Planning Application No: 3/2024/0206

Proposal: Advertisement consent for sign illuminated by a separate trough light to easterly gable of the premises.

Location: 1 Lower Lane Longridge PR3 3SL

East Elevation

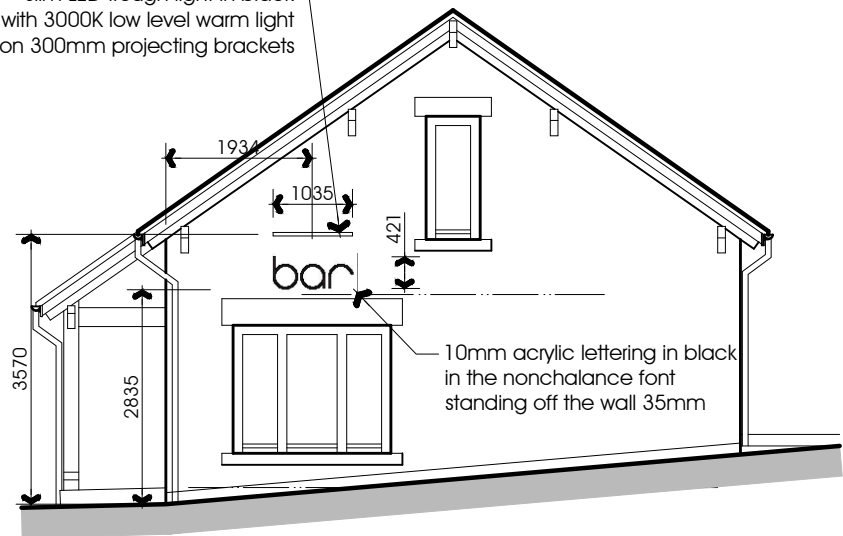
There is no objection to this proposal for the static illuminated sign 'BAR' illuminated by a separate trough light, however as the illuminance level exceeds the limit which is 600cd/m this needs amending and providing the following conditions are applied to the formal decision notice.

- The limits of the illuminance shall not exceed 600 candela per square metre. Reason: To avoid glare, dazzle or distraction to passing motorists.
- Any external source of lighting shall be effectively screened from the view of a driver on the adjoining public highway. Reason: To avoid glare, dazzle or distraction to passing motorists.
